Re: Design Advice Letter

The role of the Design Review Panel (**Panel**) is to provide independent, expert and consistent design advice on the design quality of a housing project seeking a design excellence competition exemption. The role of the panel is advisory only. The advice provided does not fetter the independence or role of the Consent Authority.

Title
C2- MATERIALS & FINISHES
MATERIALS & FINISHES

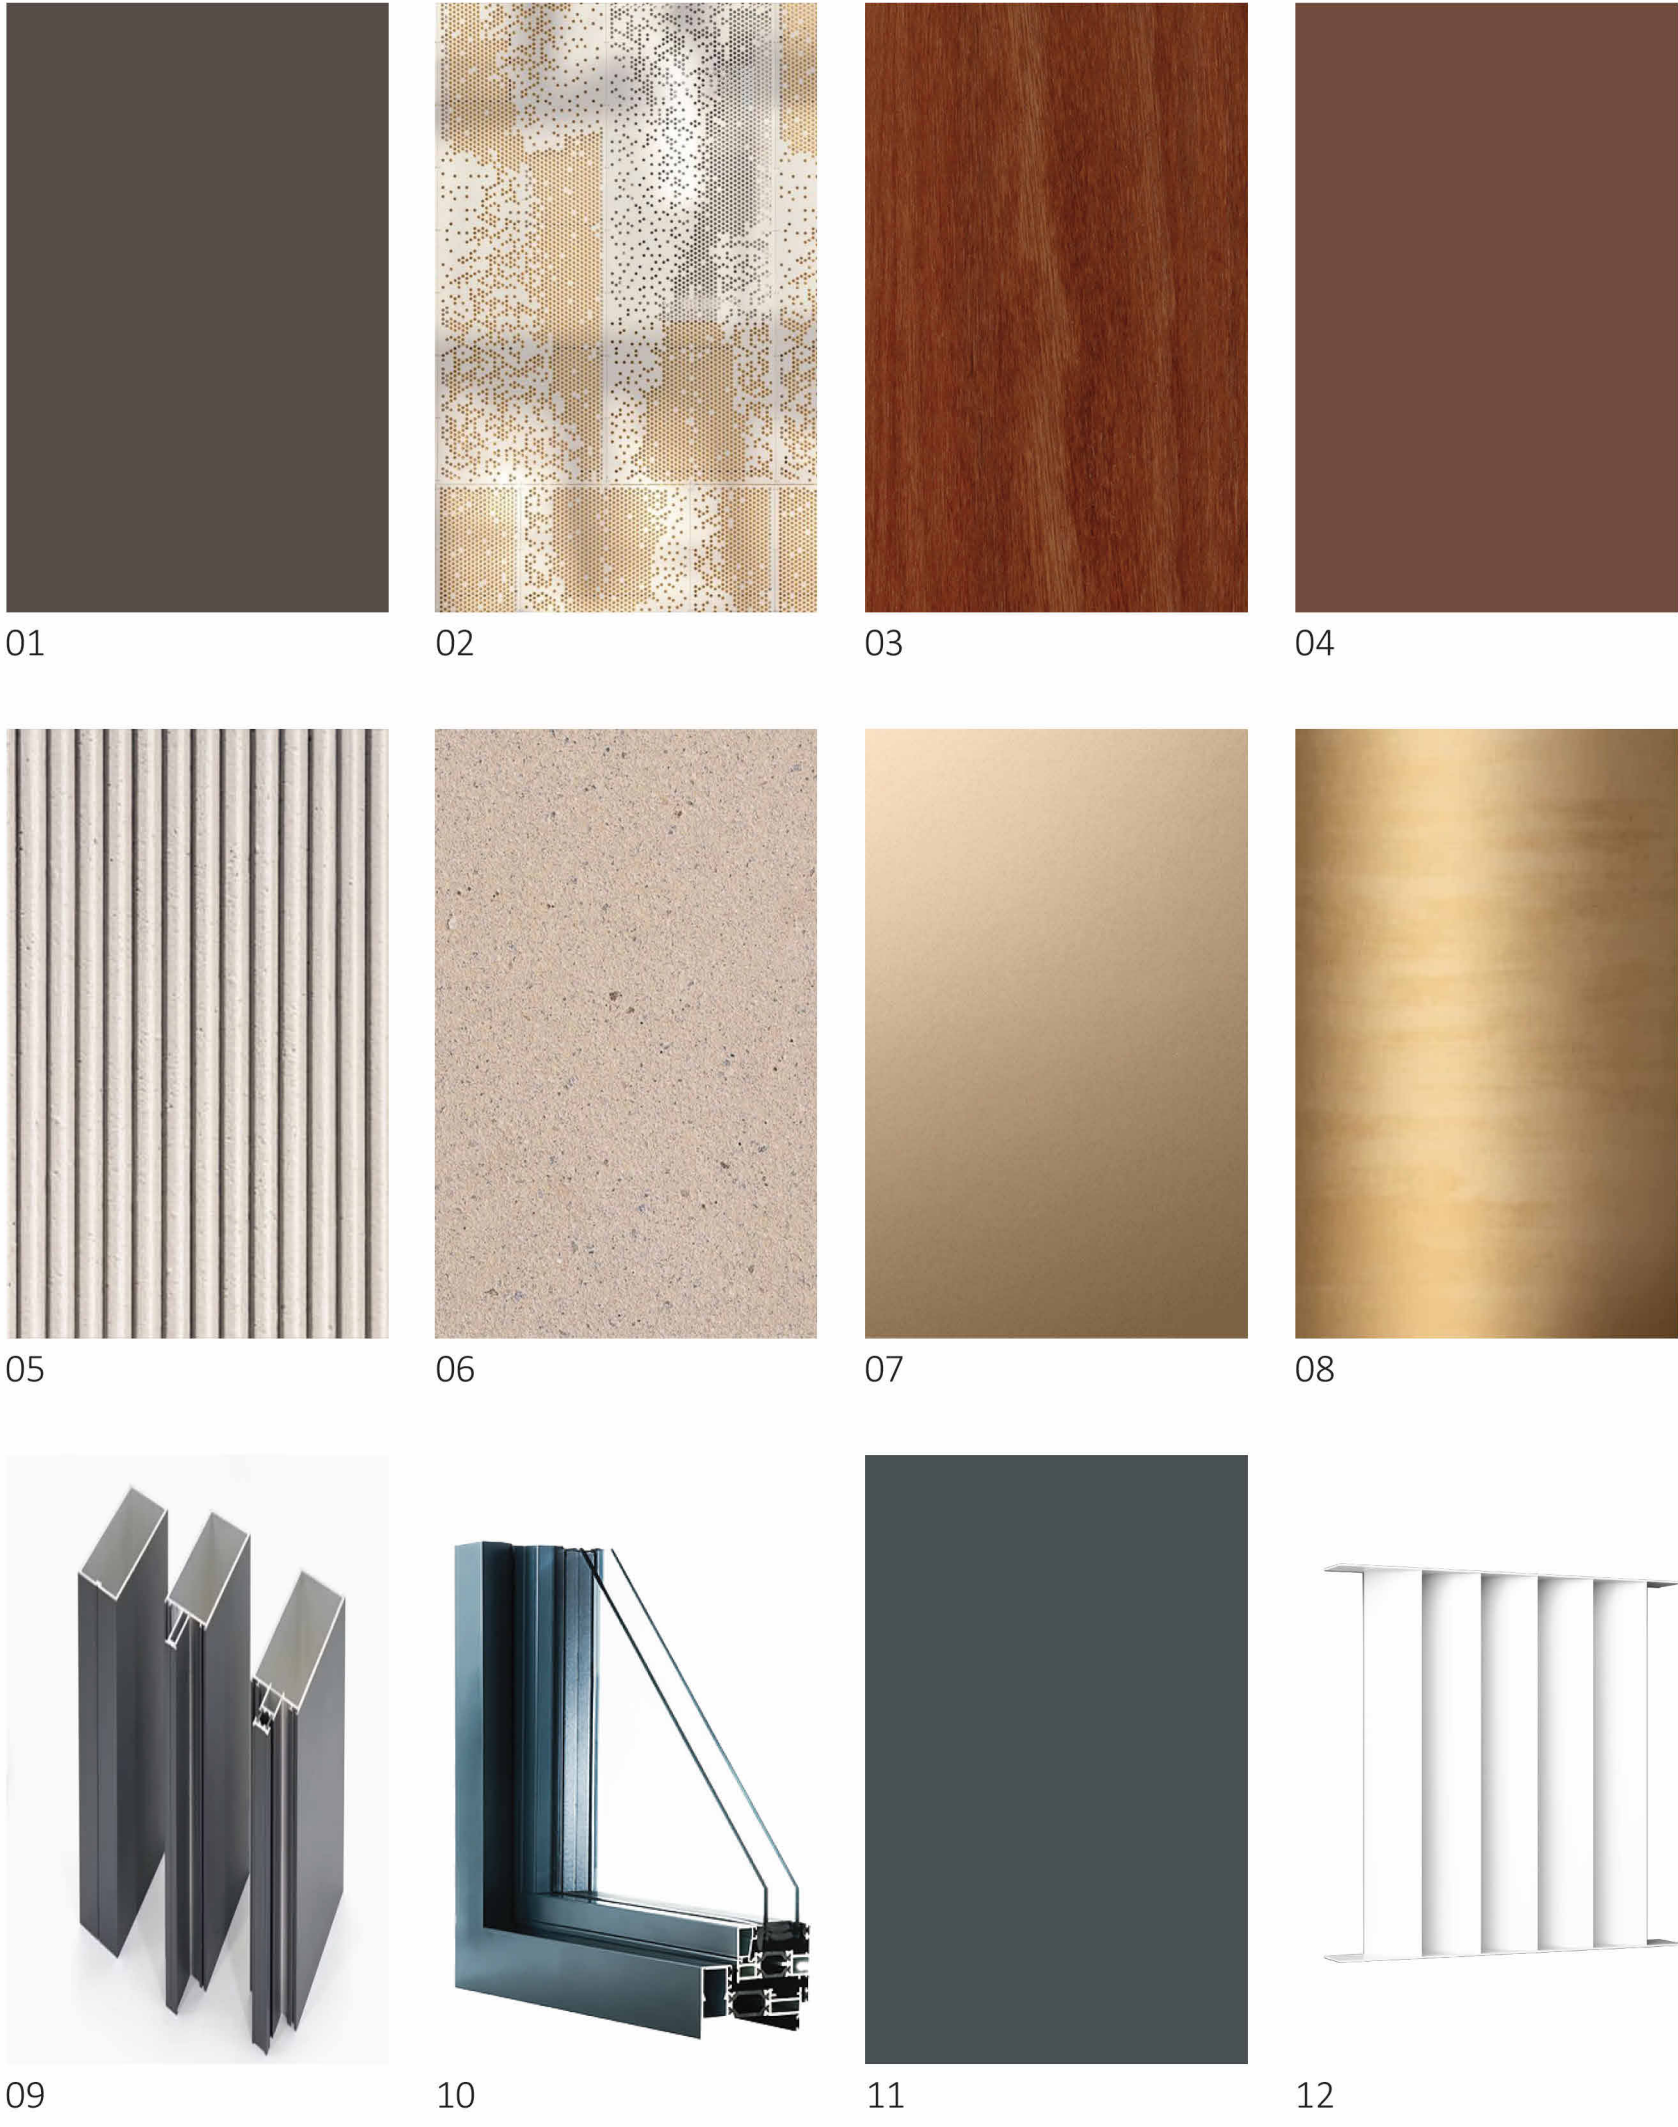
- The Applicant is to demonstrate commitment to noble materials. The Panel would like to highlight that design excellence is contingent on the quality and detailing of the materials and finishes currently proposed.

LEGEND

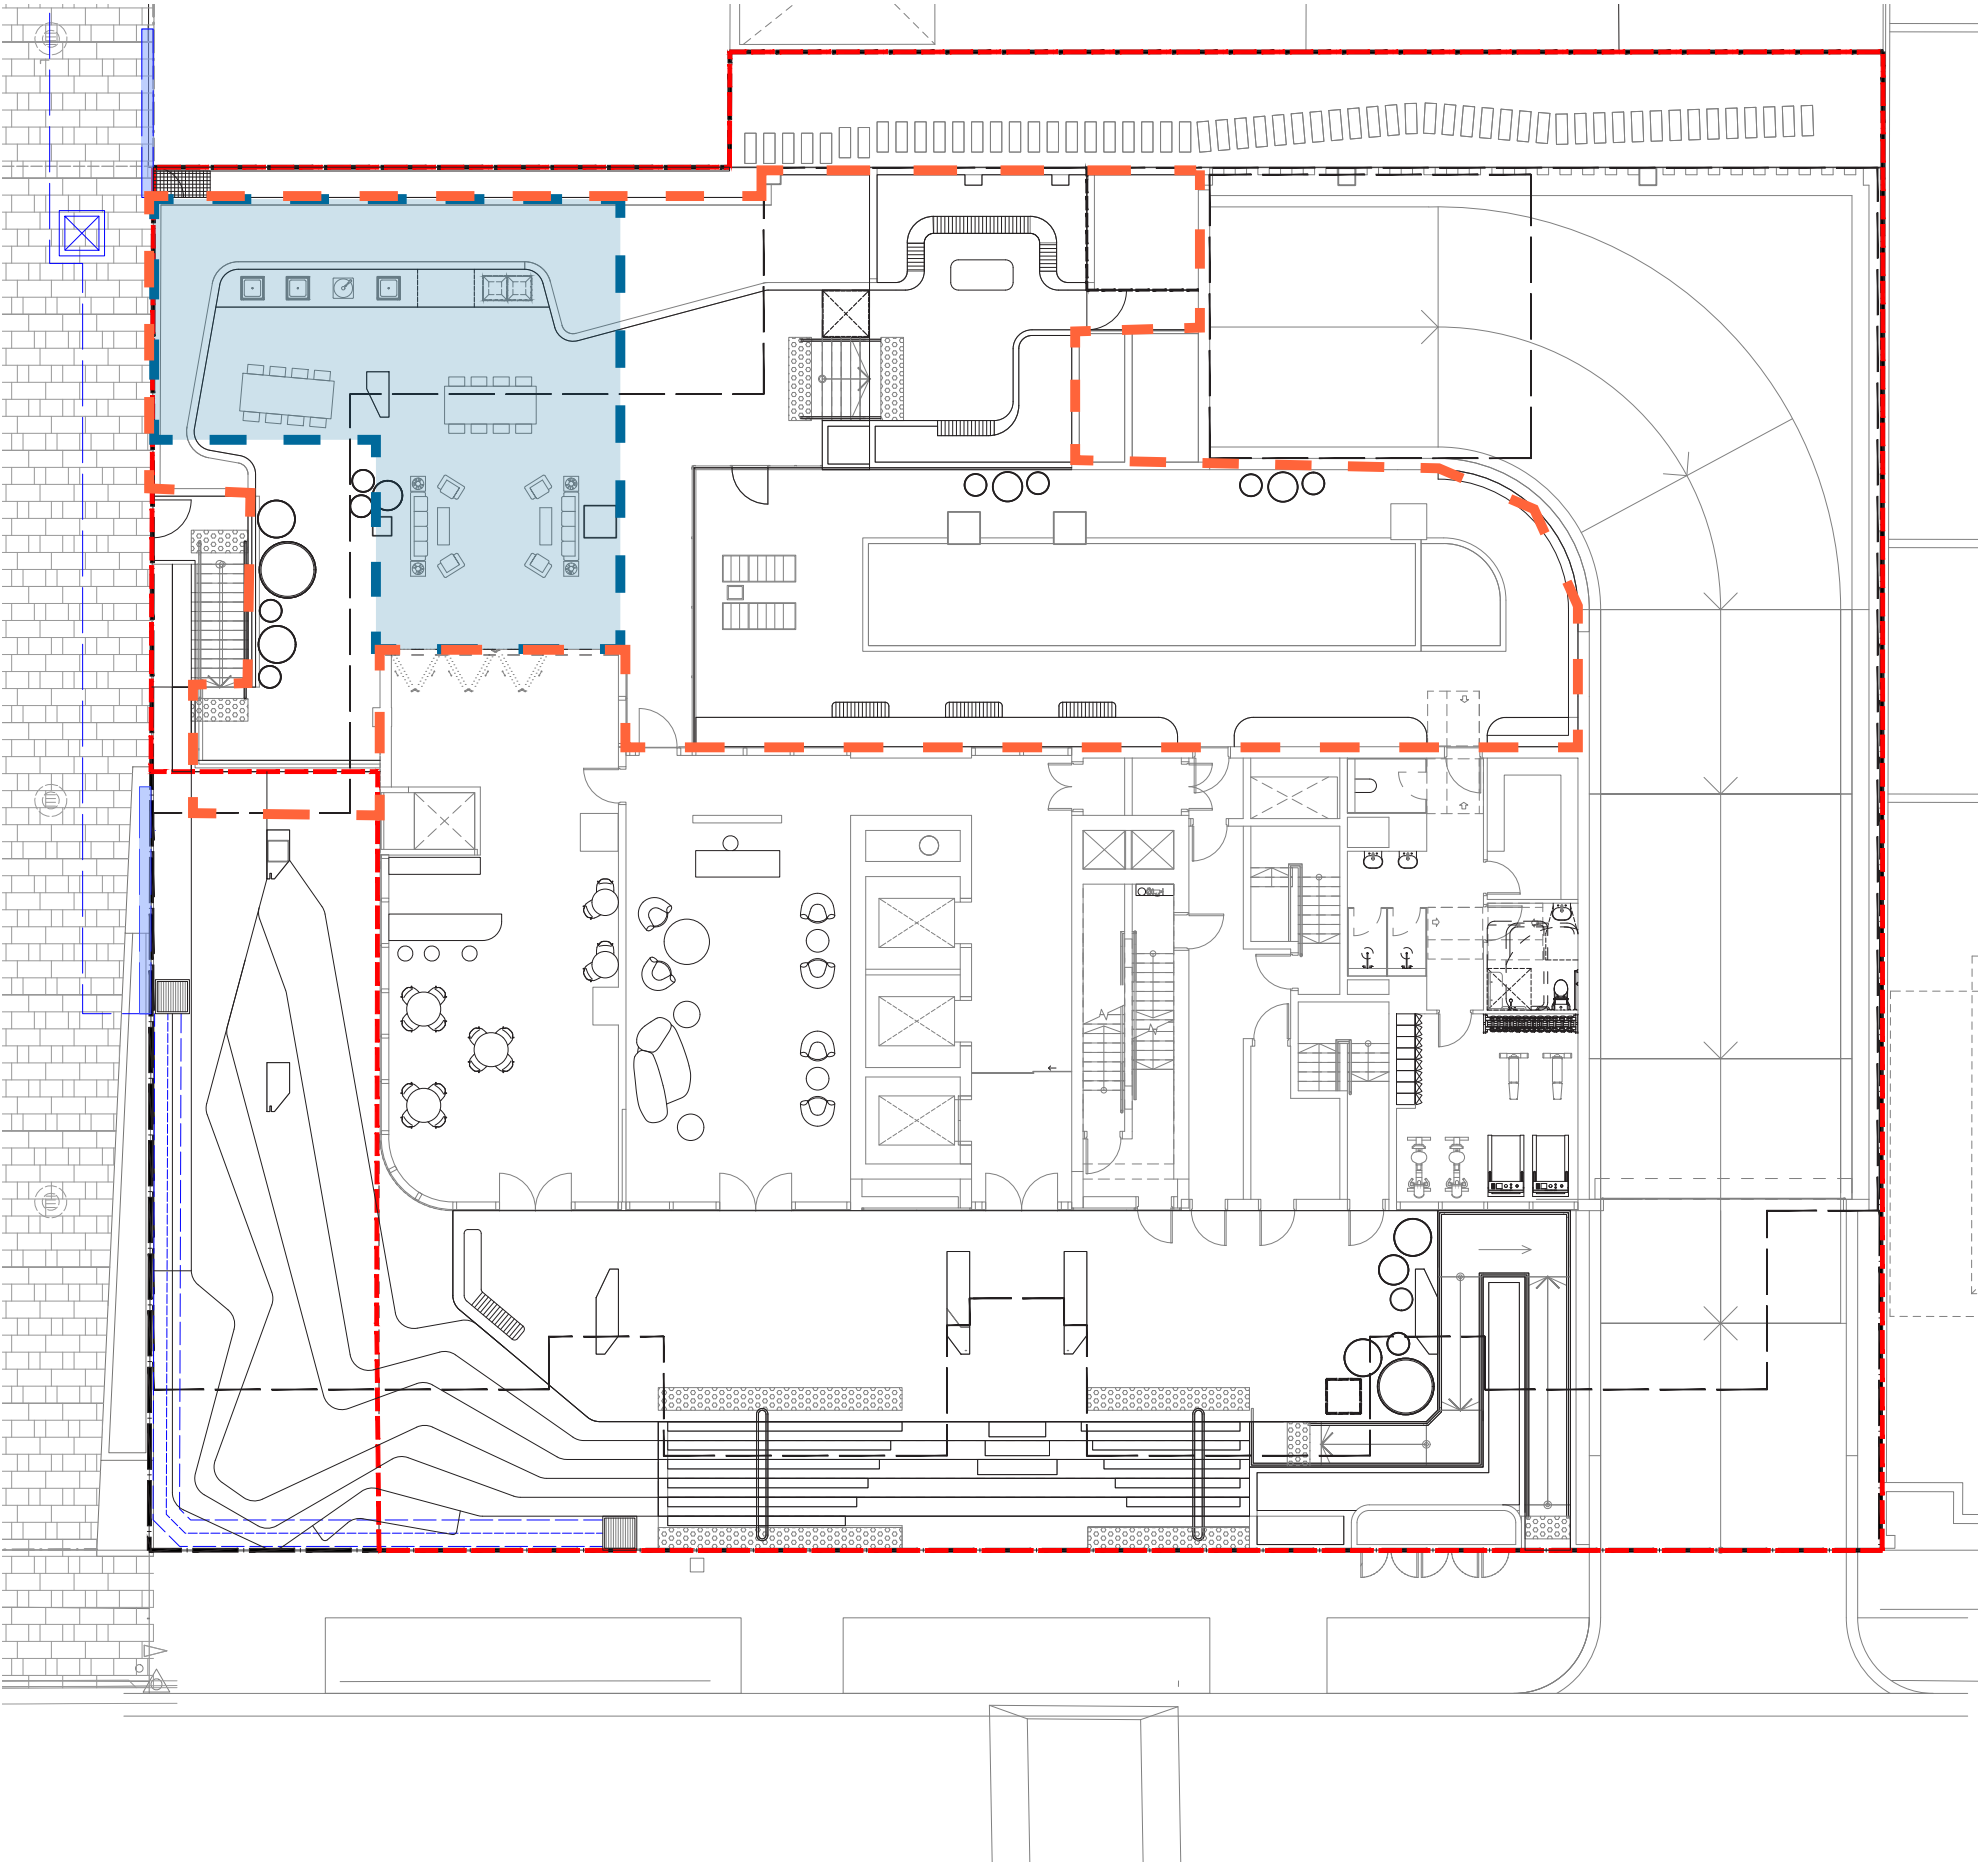
- The Panel commends the provision of a terrace at the north western corner, however the Design Team is to further explore the level changes between the northern communal space and the street level. The Design Team is encouraged to lower the level where possible to improve the relationship with the street level.
- Reconsider the appropriateness of the provision of stairs at northern interface. The Design Team is to explore alternative ways of activating the northern interface.
- Further consideration is to be given to the location of the object artwork and its potential implications to wayfinding and concealing the residential entries.
